**WELWYN HATFIELD BOROUGH COUNCIL – DEVELOPMENT MANAGEMENT
DELEGATED REPORT**

| APPLICATION No: | W6/2012/2295/EM |
| APPLICATION Site: | 12 Fordwich Road |

Drawn By:	DAMIEN	Scale:	1:100	Date:	OCT 2012
Discipline:	PLANNING	Checked:			
Drawing No:	2908-P01	Revision:			A1

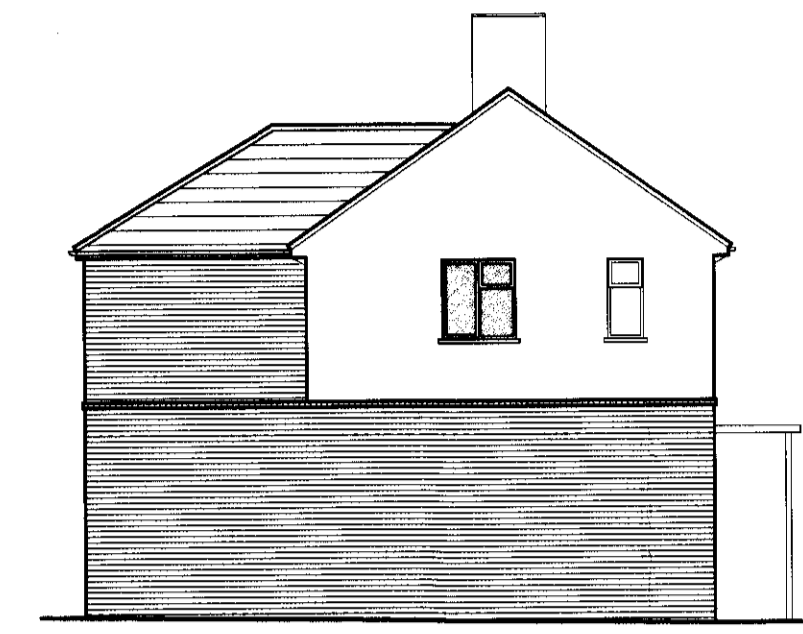
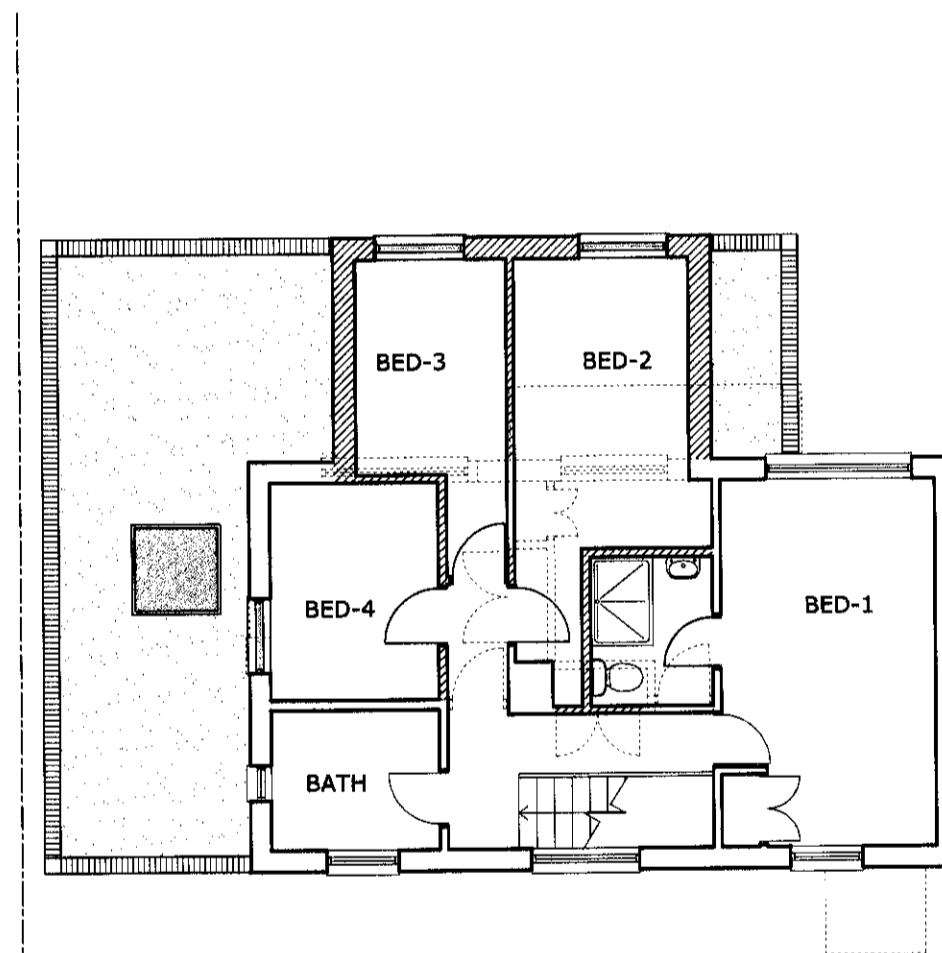
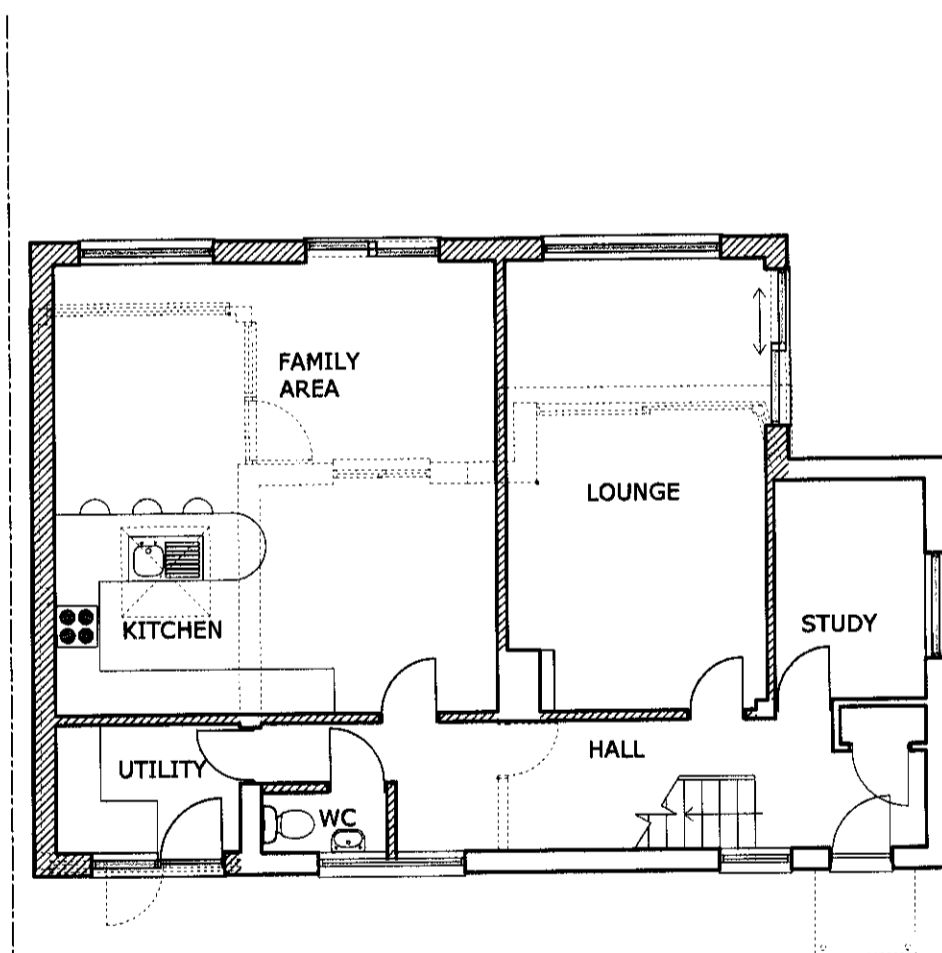
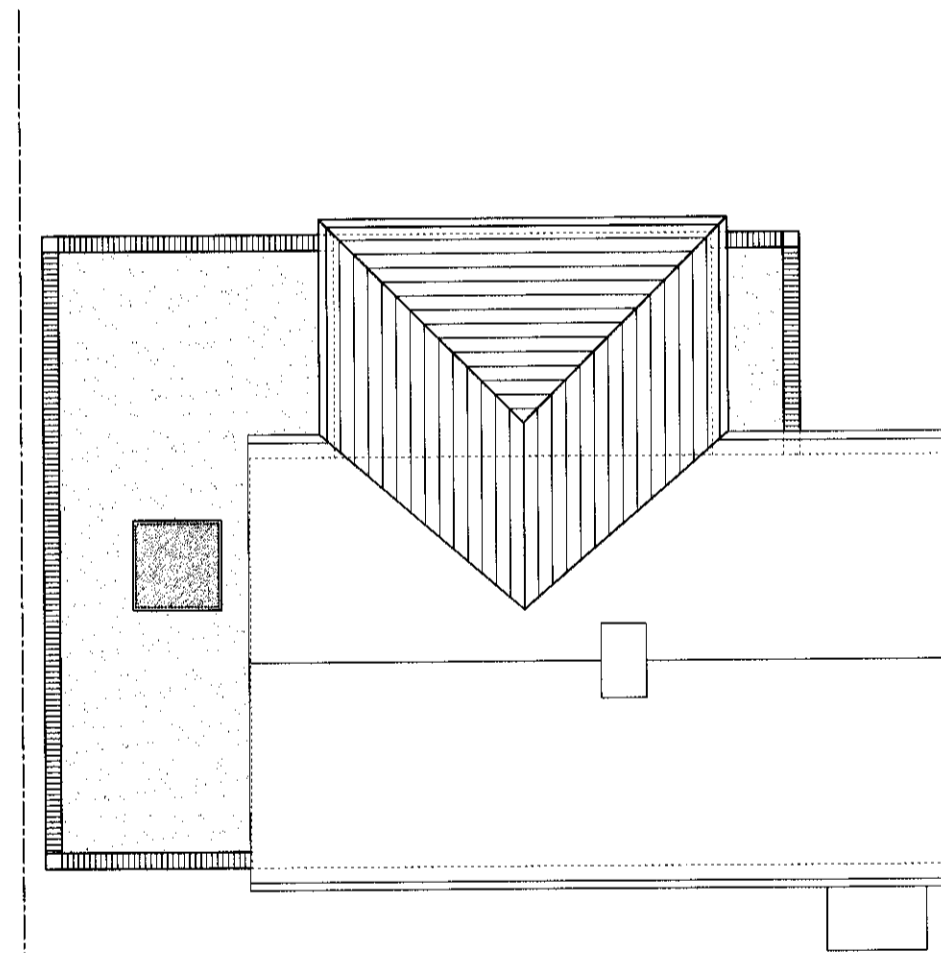
The proposal would add only modestly to the depth of the property, reaching a maximum of approximately 3.0m at one point. Whilst quantitatively the development represents an appropriate addition, by developing along more than 80% of the width and by being two storeys in part, the result is a visually more sizeable addition. However, it is considered that the reduced ridge height of the first floor extension, along with the modest increase in depth, alleviate the harm caused, resulting in an appropriately subordinate addition.

The development would incorporate the use of matching materials and fenestration, and the design would reflect that of the existing property. Whilst the roof at first floor level would be hipped, rather than gable ended, it is considered that this design would be of an appropriate addition to the dwelling, particularly given its more visually concealed location to the rear.

Windows would be constructed at first floor level on the side and rear elevation of the property, resulting in potential overlooking impacts. The proposed side window would be an enlargement of an existing window and would overlook the rear garden of 14 Fordwich Road. However, the window would only overlook the bottom of the garden. Furthermore, there are existing windows on this elevation and it is considered that there would not be any further additional impacts. Whilst the rear first floor windows would be closer to the rear boundary of the property, no additional overlooking impacts would result.

The proposal has been amended from its original state. These amendments resulted in the reduction of scale and the re-positioning of the first floor extension from the side to the rear in order to protect the amenity of neighbouring property of 14 Fordwich Road. It was considered that re-consultation with neighbouring residents was not necessary.

6. The development/works shall not be started and completed other than in accordance with the approved plans and details: 2908-PO1 Rev A1 received and dated 21 December 2012 & Block Plan & Site Location Plan received and dated 5 November 2012 unless otherwise agreed in writing by the local planning authority.
